From: Pendry, Glenn [REDACTED]
Sent: 01 December 2020 08:38
To: Anita Gardner <Anita.Gardner@arun.gov.uk>
Cc: 'Lynnette St quintin' [REDACTED]
Subject: AB/63/20/DOC 74-76 Canada Road, Arundel, West Sussex BN18 9HY - Planning Extension of Time

Condition 4 – Construction Plant and Materials

Condition 8 - Access

Drawing No.	Status
15718-HOP-ZZ-XX-DR-C-10008	S0 P3

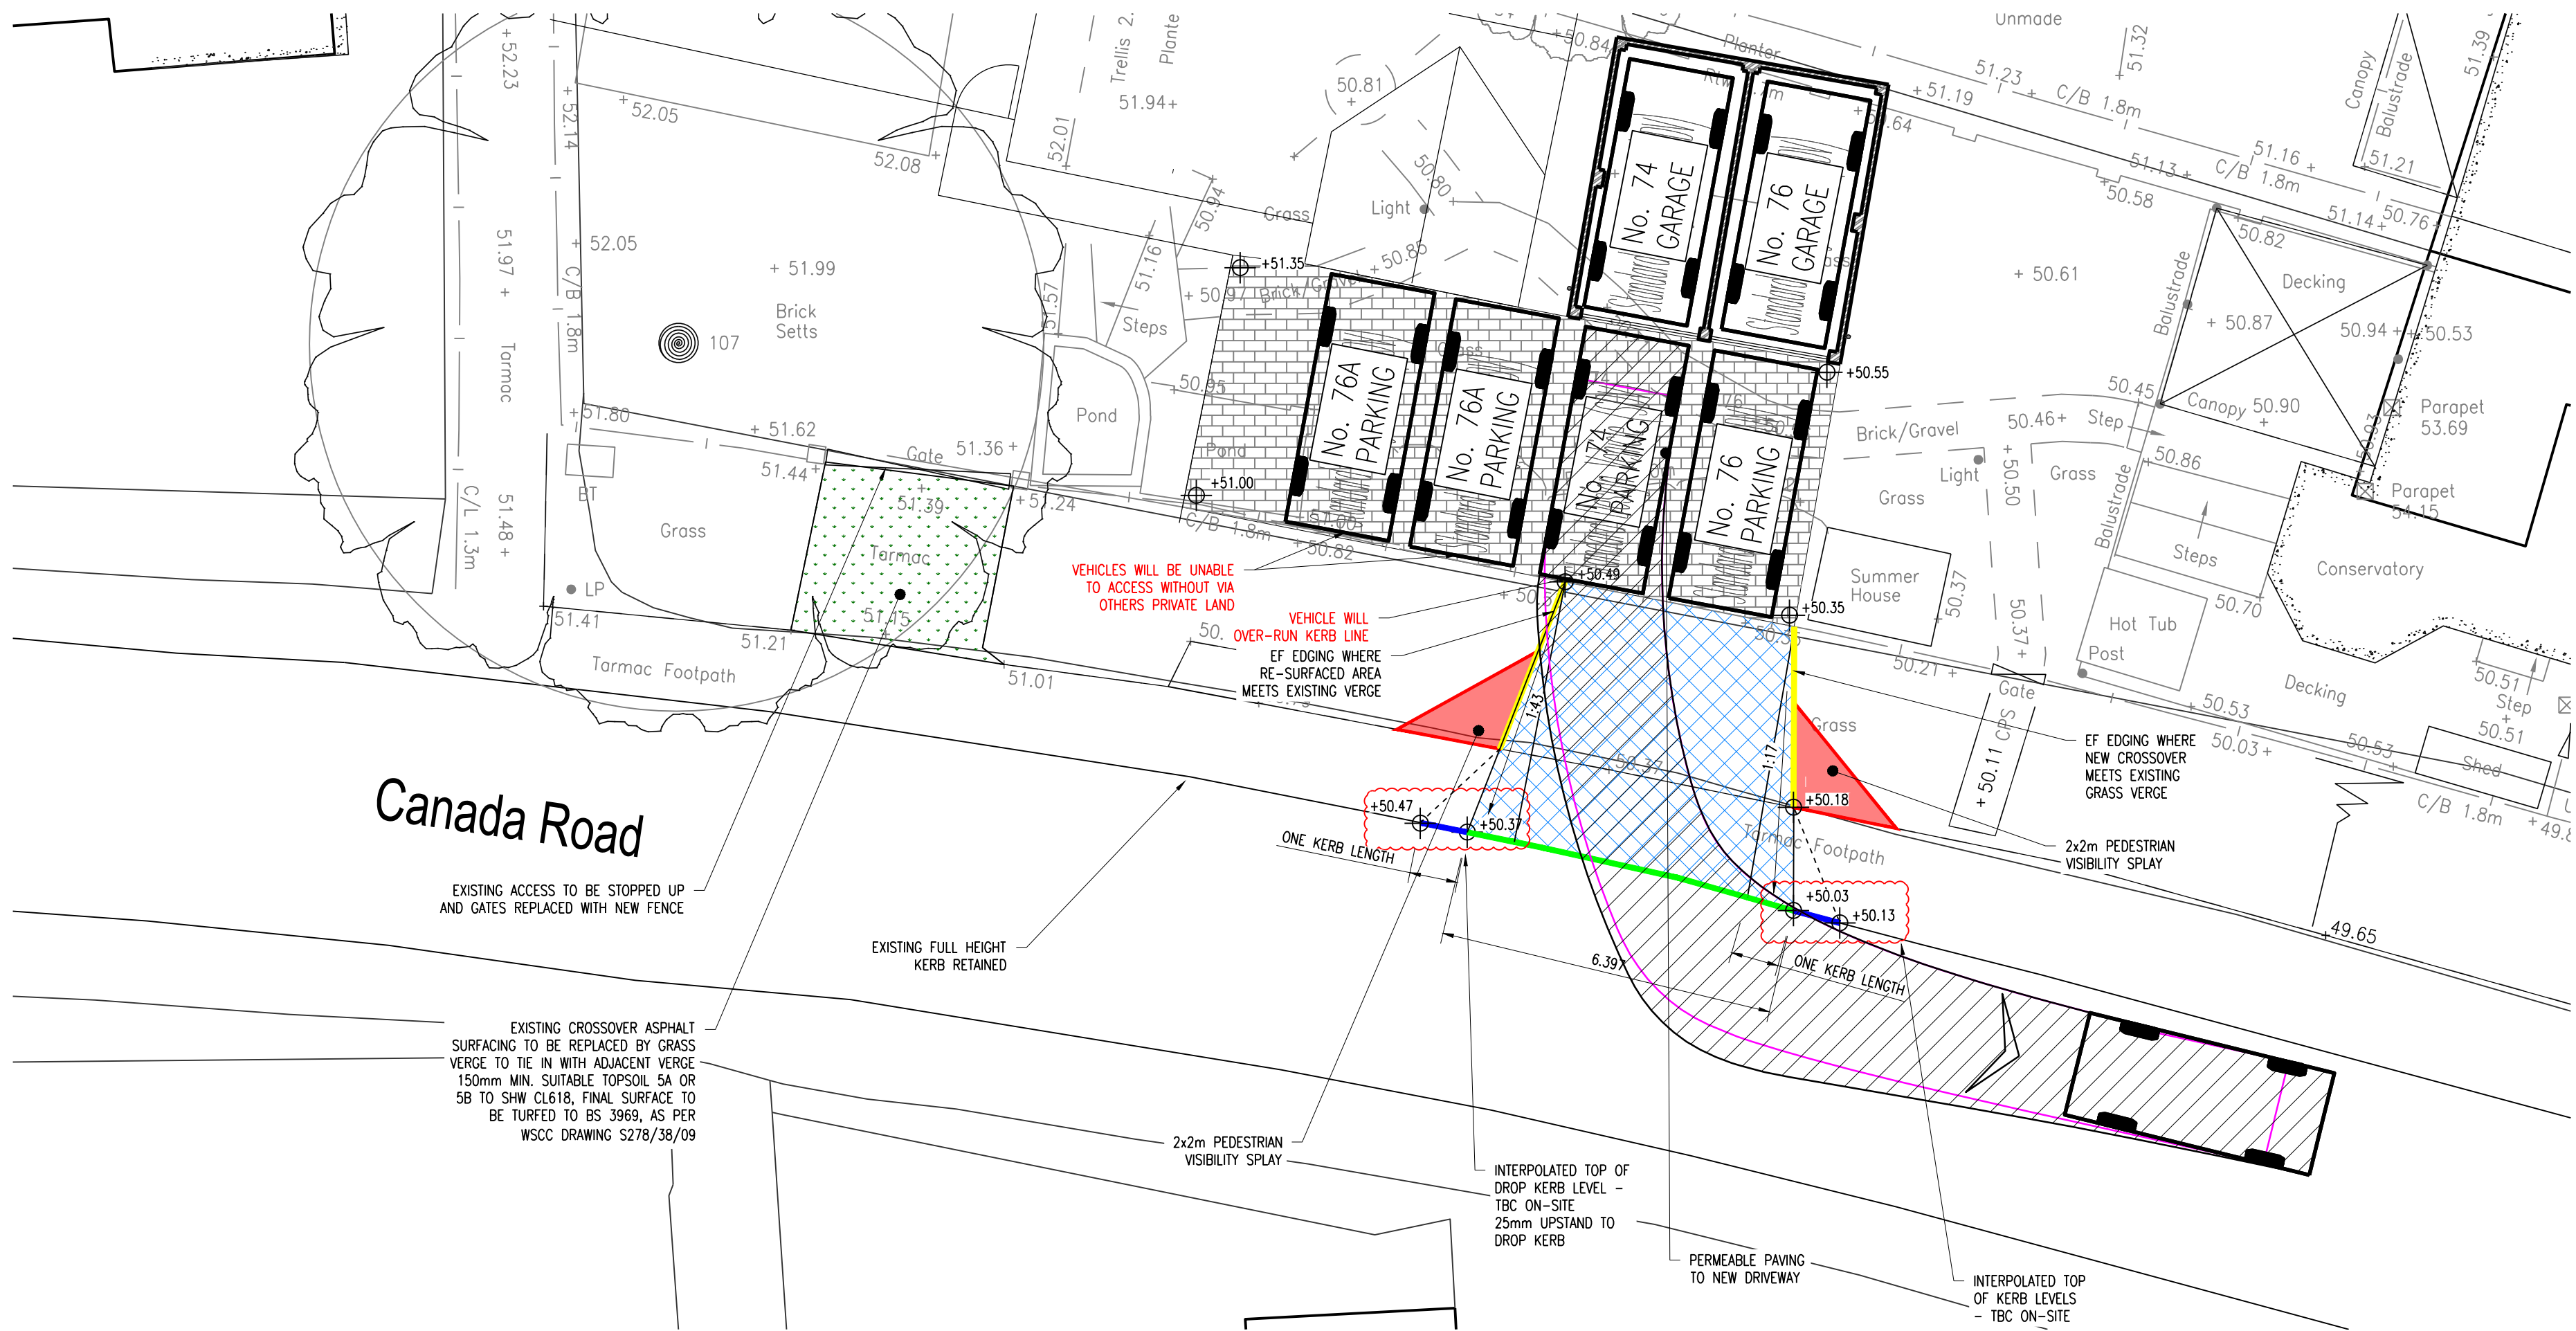
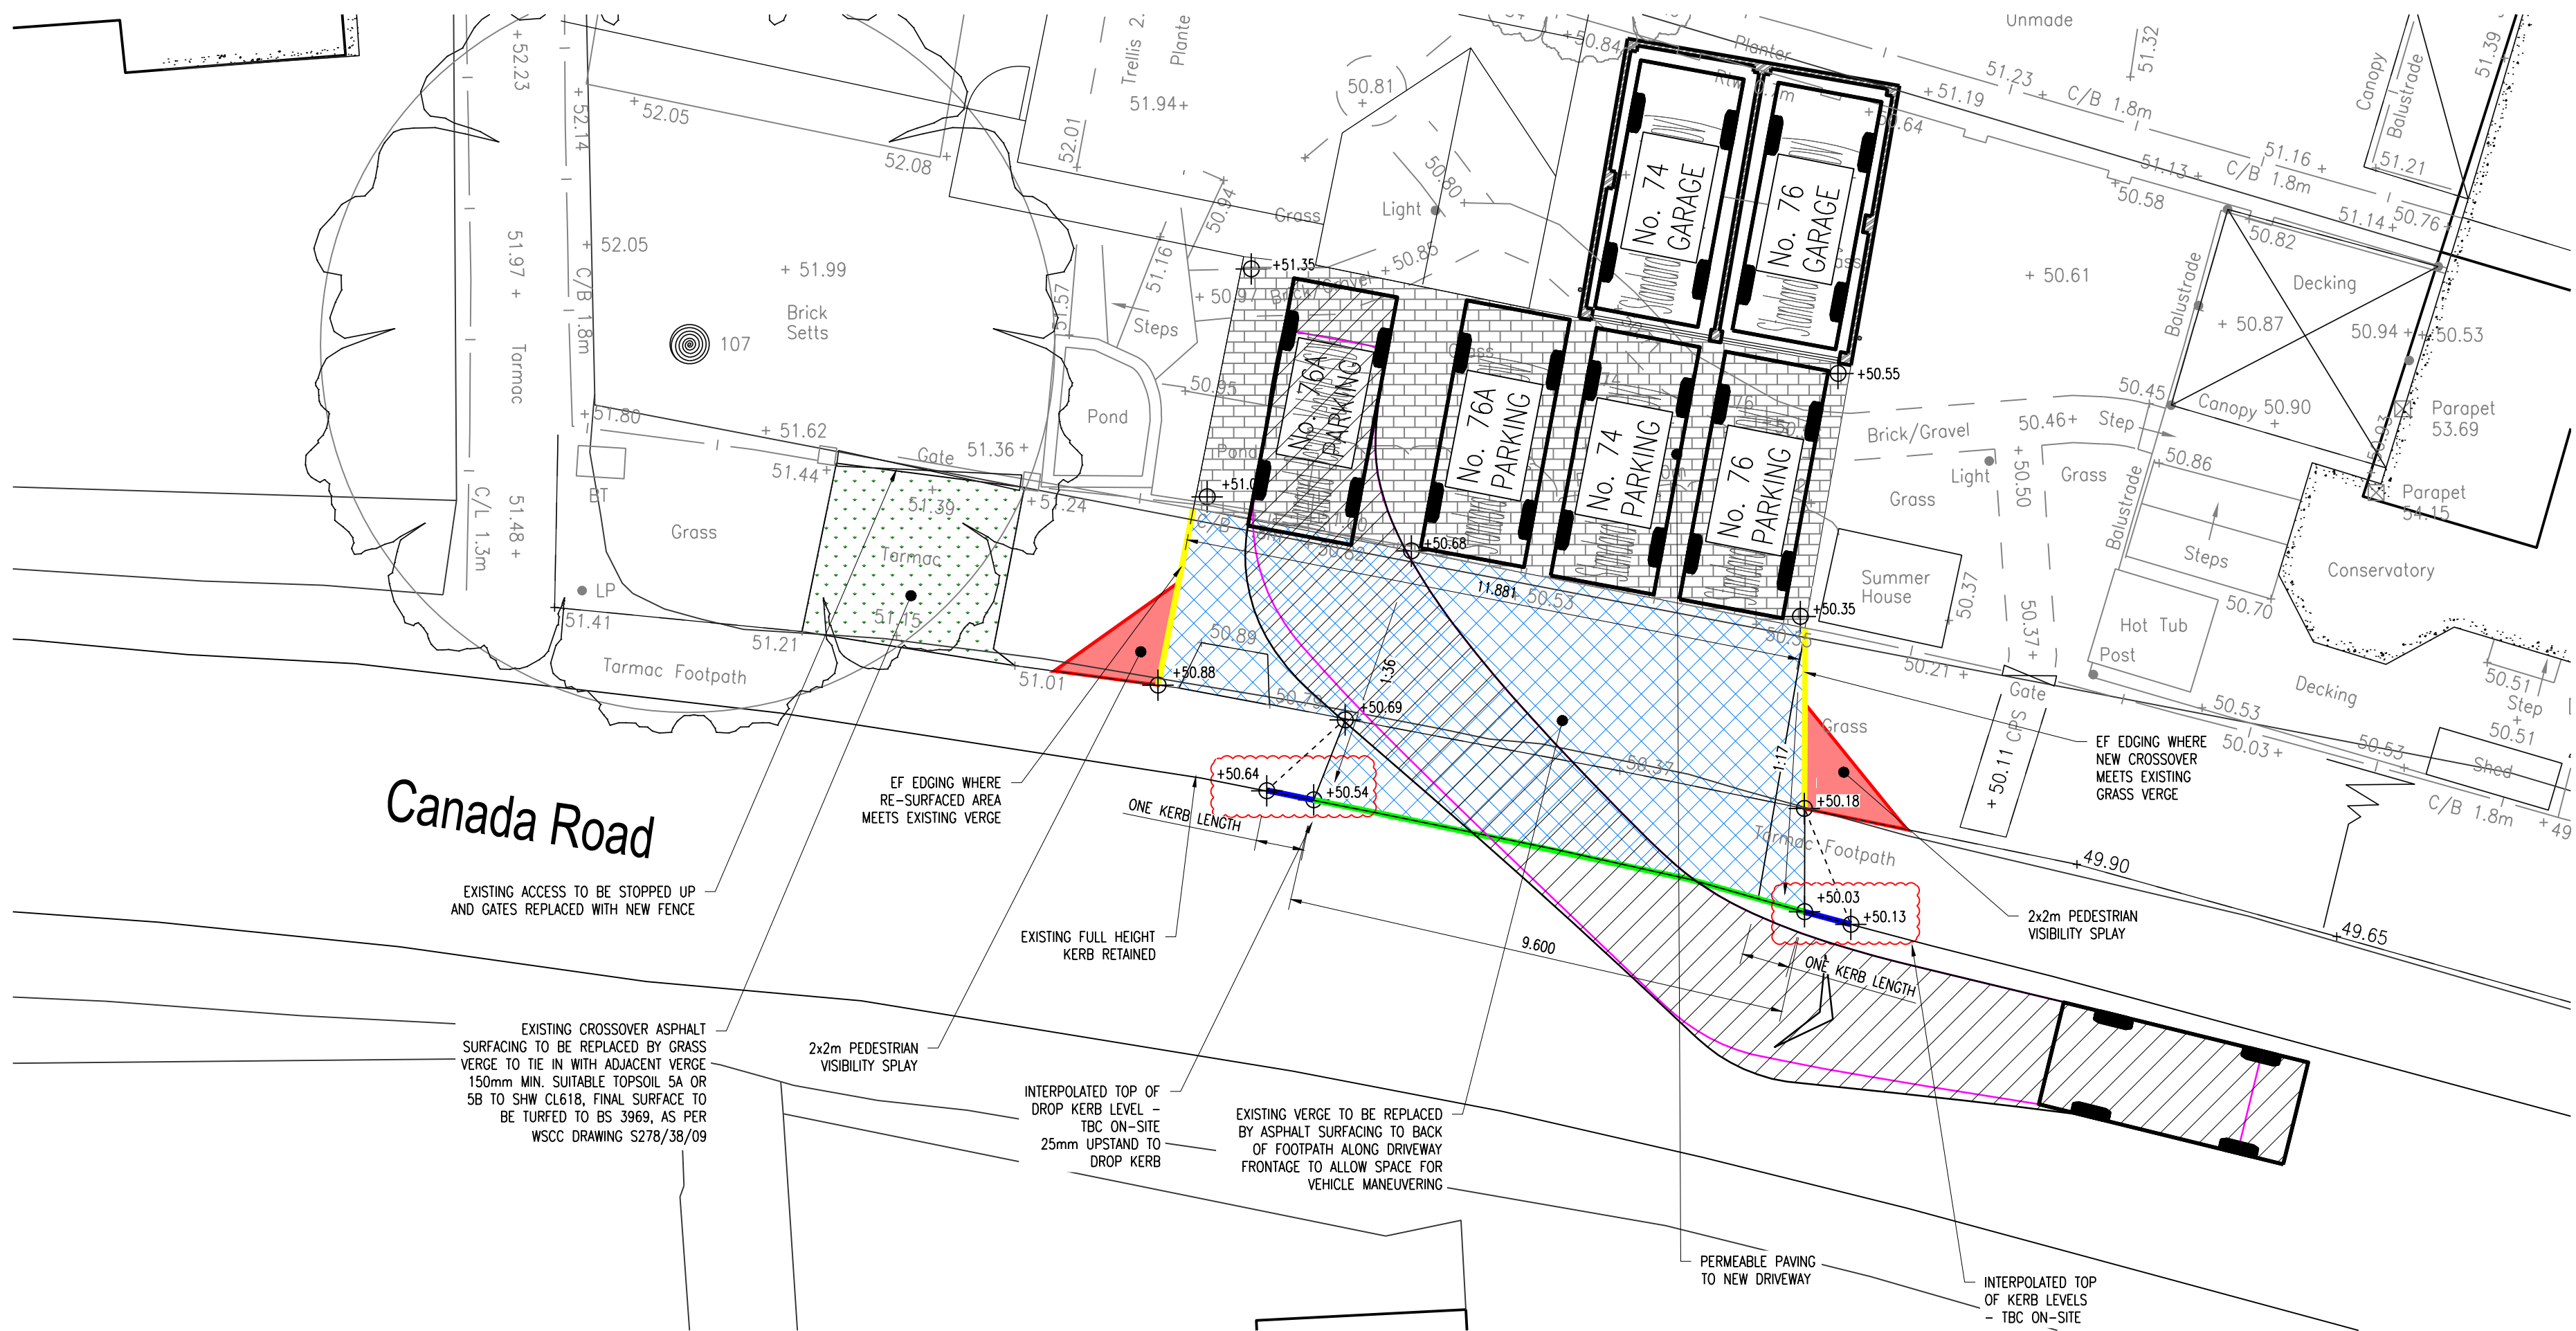
Am I right in thinking they have not submitted any plans that show a reduced width crossover at 6.4m wide? I can’t see such plans on the Arun Planning Portal or on the email string. The latest seems to be Plan 101A as attached to one of Glenns emails.

Glenn seems to be asking if a crossover width of 9.6 metres would be acceptable. I can see the logic behind this as it would allow for convenient access to the garage spaces and hardstanding for 74 and 76 Canada Road and allow for access to the proposed parking spaces for the new dwelling. To my mind a 6.4m wide crossover may limit accessibility for some of the spaces, though its difficult to say this with any certainty as that has not been demonstrated to date.

Our area office are resistant in granting licence application grater than 6.4 metres in width due to the loss of on street car parking provision. I think the only way forward is to present to the area office a plan that shows how a 6.4m wide crossover is not workable. I.e. showing a 6.4 crossover where it is then clear that vehicles accessing the new parking spaces will be required to bump the kerb in order to access the approved parking spaces. A similar plan showing a 9.6 metre wide crossover or greater can then be provided to show the minimum width required to provide a workable solution. This will then be materially different to what we have presented to the area office with to date to provide us a view on.
